**MT THORLEY CONTINUATION PROJECT (SSD 6465)
RESPONSE TO SUBMISSIONS REPORT**

Reference is made to your email to the Environment Protection Authority (EPA), dated 11 November 2014, seeking the EPA's comments on the report titled '*Mt Thorley Operations 2014 – Response to Submissions Report: November 2014*' (RTS report) prepared by EMGA Mitchell McLennan Pty Limited.

EPA's Air Quality Assessment Comments
Mount Thorley Operations Continuation Project (SSD 6465)

Figure 4-5: TEOM 24-hour average PM₁₀ concentrations at MTW and Hunter Valley Operations monitors

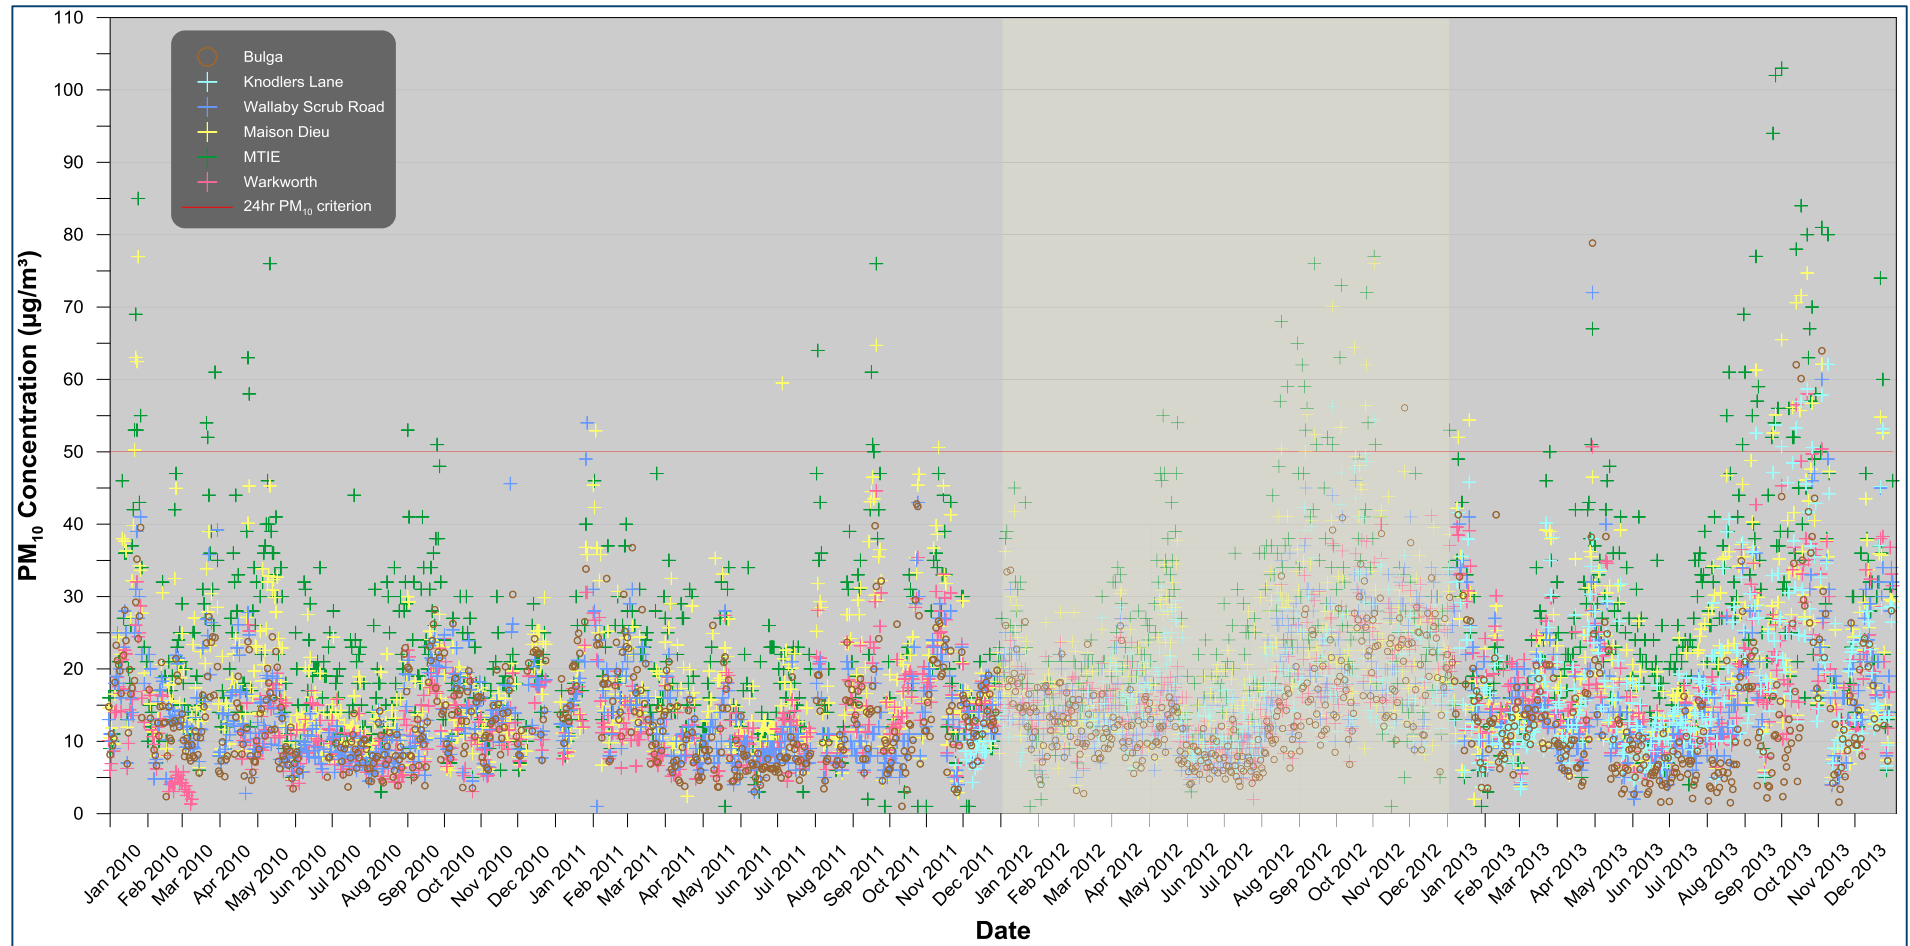
The 2012 emissions inventory was not included as an appendix to the RTS report. The background levels shown in the original Environmental Impact Statement (EIS) and the RTS report appears to be the monitored concentrations at the TEOMs when compared with the monitoring data in Appendix B of the Air Quality Impact Assessment (AQIA). This differs from the background dust level methodology described in the RTS report.

Additionally, it appears there are inconsistencies with the dates of some of the monitored background concentrations in the 24-hour PM₁₀ cumulative assessment and the tabulated TEOM data in Appendix B of the EIS. For example, Appendix B of the EIS does not include the measured concentration at the monitors for 7 October 2012 and the measured concentration on 14 June 2012 at the Bulga TEOM was 12 µg/m³. These dates and a number of other dates have different concentrations to the background concentrations presented in the 24-hour PM₁₀ cumulative assessment tables.

The proponent should provide the 2012 predicted impacts for everyday of the year for the Project alone and Project with Warkworth for transparency. Additionally, the proponent should check that the date and background concentration used in the cumulative assessment is consistent.
